PROJECT TITLE: Barelas Court Townhomes ZONE ATLAS/DRNG. FILE #: K-14 / 1042

BARELAS COURT TOWNHOMES  
DRAINAGE REPORT

RE: REVISED DRAINAGE PLAN/REPORT SUBMITTAL OF BARELAS COURT  
TOWNHOUSES (K-14/D42) REVISION DATED MARCH 13, 1989 RECEIVED  
MARCH 14, 1989

RE: DRAINAGE REPORT SUBMITTAL OF BARELAS COURT TOWNHOUSES, RECEIVED  
NOVEMBER 7, 1988, FOR PRELIMINARY PLAT AND SITE DEVELOPMENT  
PLAN APPROVALS. (K-14/D42)

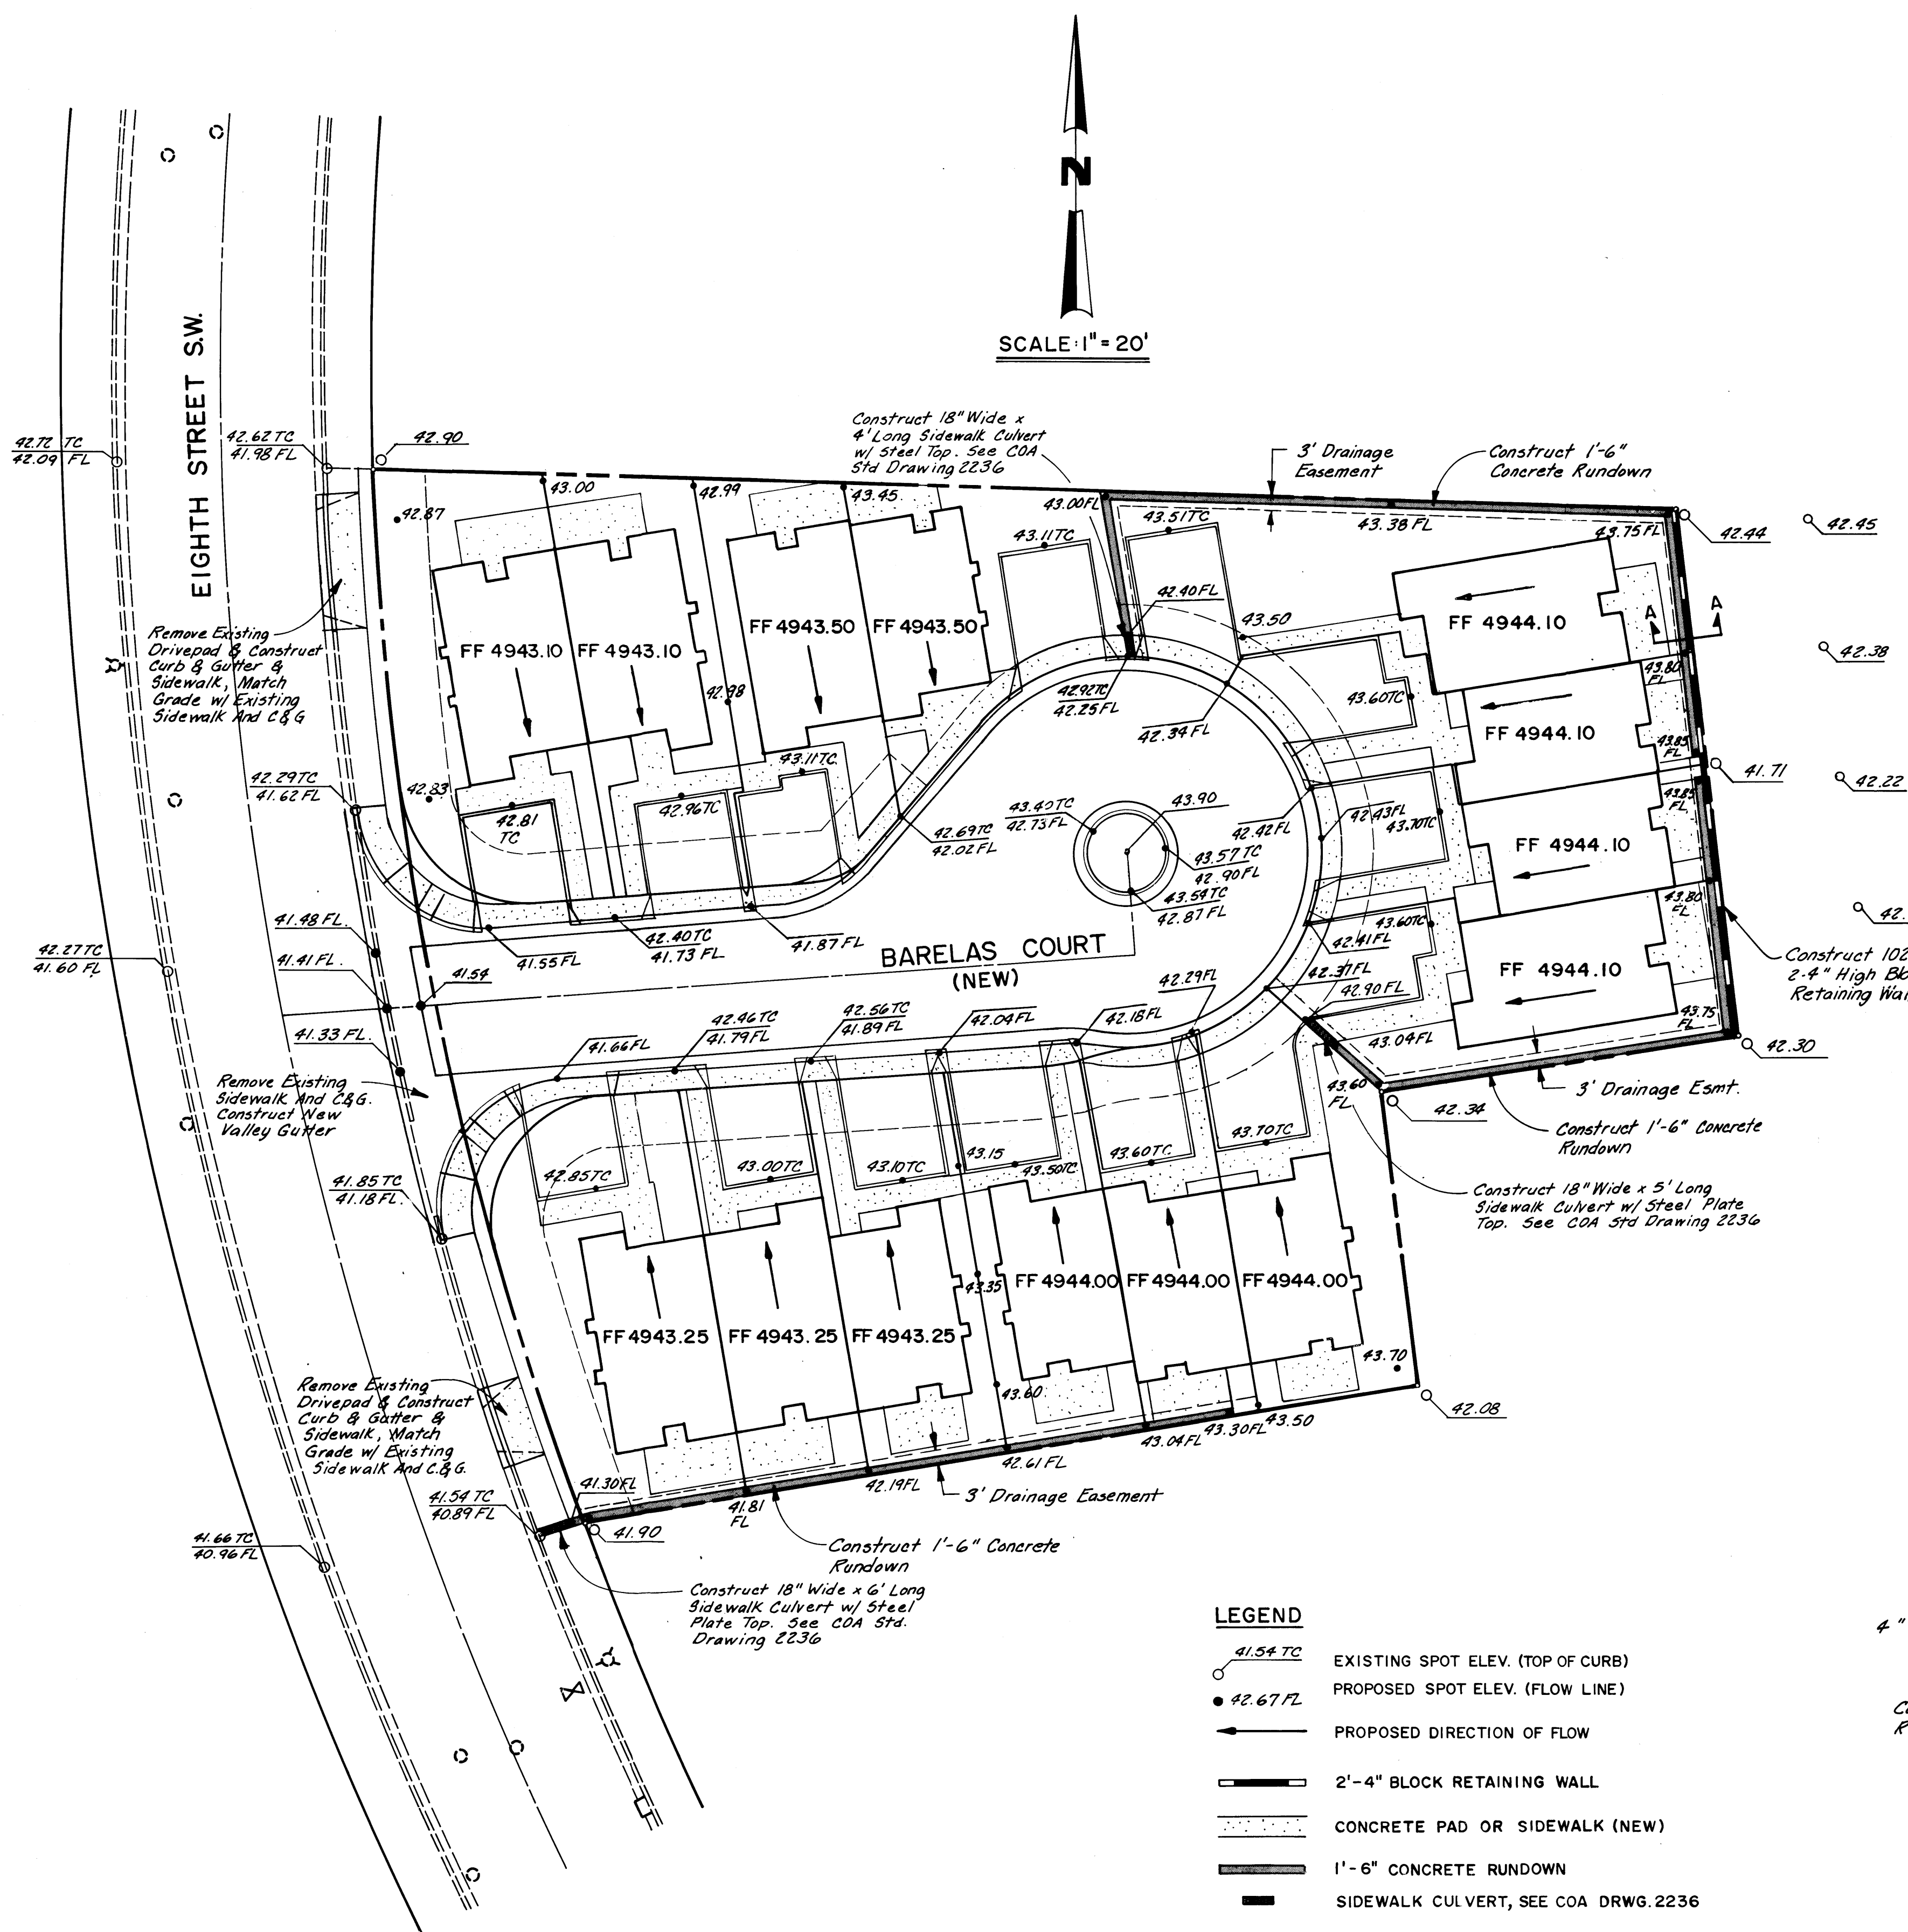
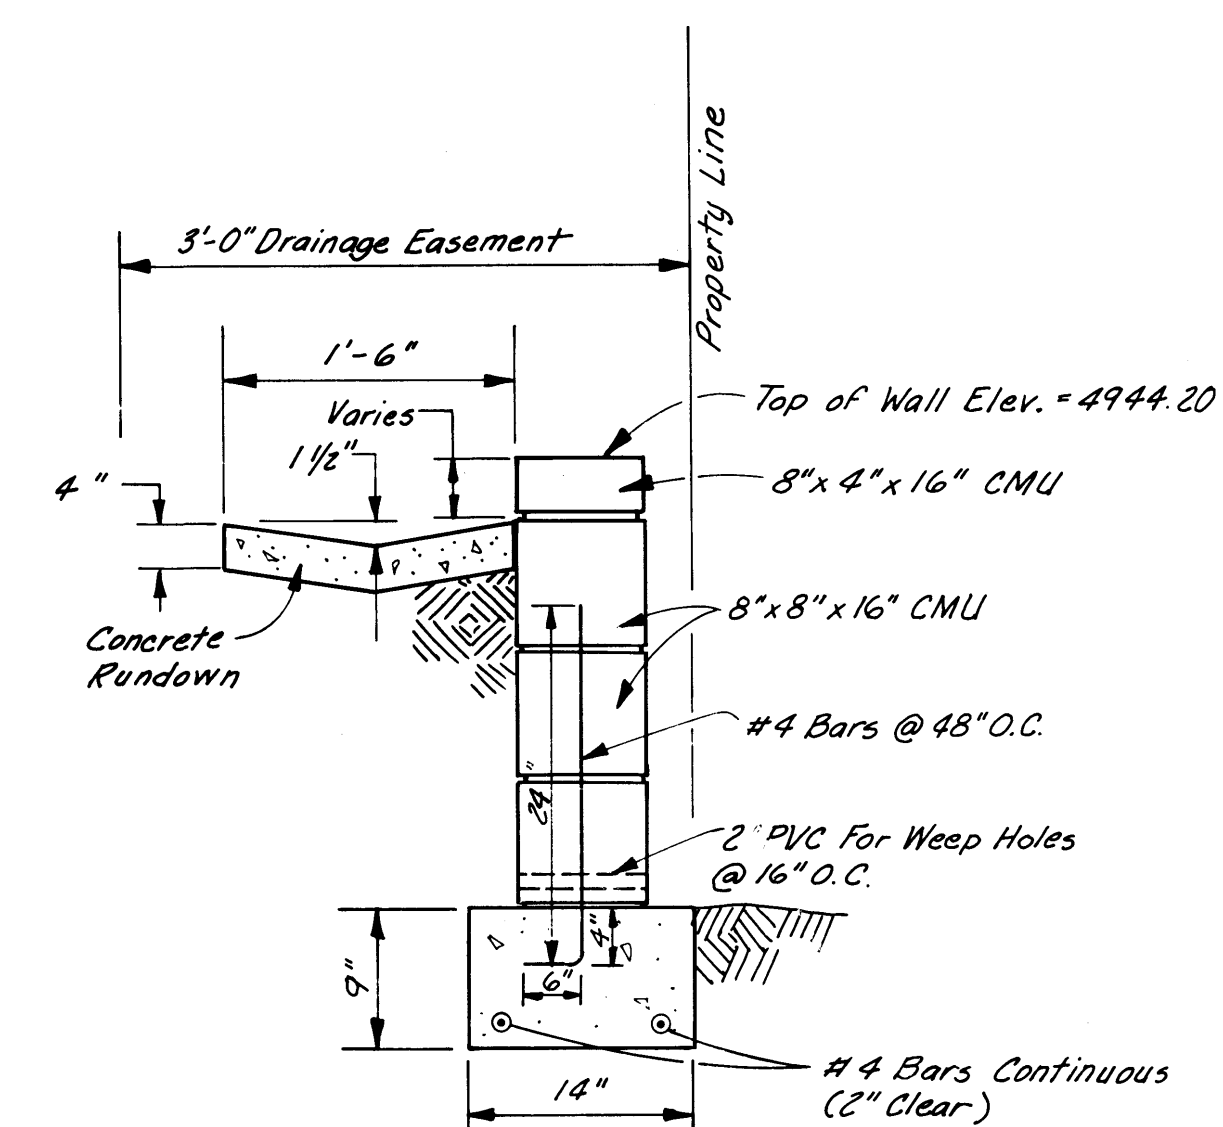
1. The rear yards for lots 6, 7, 10, & 13 must be provided an outfall for surface drainage, either between the buildings or with drainage easements across adjacent lots. For lots 5 thru 8 I recommend providing space between lots 5 & 6 and 7 & 8, or else provide drainage easements and concrete gutters around the corners. For lots 9 thru 14, I recommend that drainage easements be provided along the south property line with a concrete gutter built along the rear lot line sloping east to west, and direct the runoff into 8th Street through a sidewalk culvert.
2. Provide the existing condition hydrology for the area draining to the low spot prior to it's backfilling.
